28 November 2016

**APPLICATION TO MODIFY EXISTING PROJECT APPROVAL MP 08_0157, JOE WHITE
MALTINGS, STONNY BATTER ROAD, MINTO**

Figure 5 Proposed Short Lane Extensions

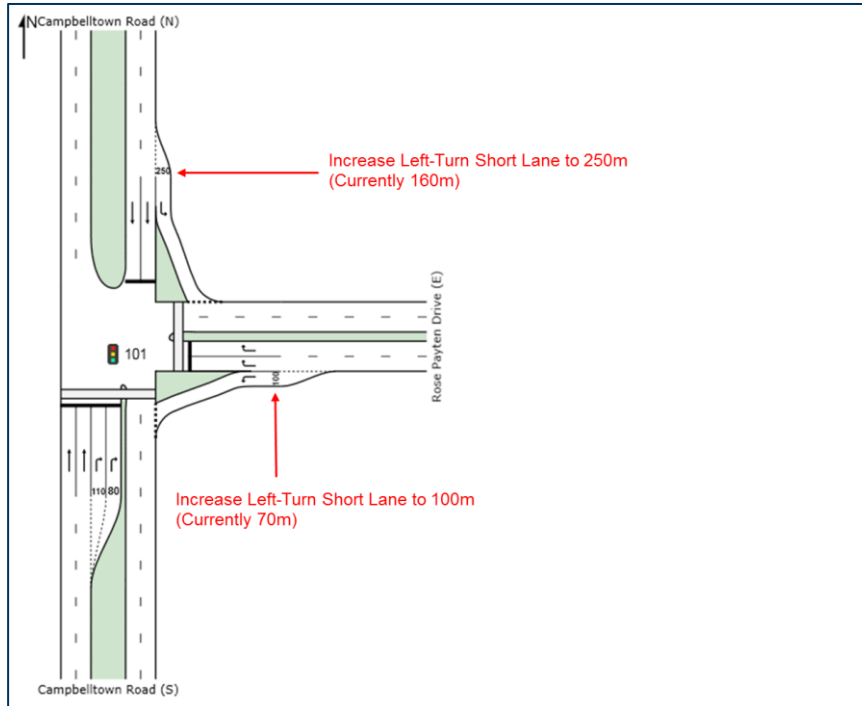
Operational Level of Intersection. The traffic report indicates that the signalised intersection of Rose Payton Drive/Pembroke Road and Campbelltown Road/Rose Payten Drive will operate at Level of Service F in 2016. Furthermore, it is noted that some of the movements at these intersections currently (2016) operate at Level of Service F. The applicant is to identify the required mitigation measures to ensure these intersections operate at an acceptable level, now and in the future.

Cardno have responded in detail in **Appendix 3**. Cardno has reviewed the Rose Payten Drive / Campbelltown Road intersection and notes that both the southbound left-turn short lane, and the westbound left-turn short lane queues may extend into the adjacent full-length lanes, reducing its capacity. Accordingly, it is recommended that the southbound left turn short lane to be increased to 250m from 180m, and the westbound left-turn short lane to 100m from 70m.
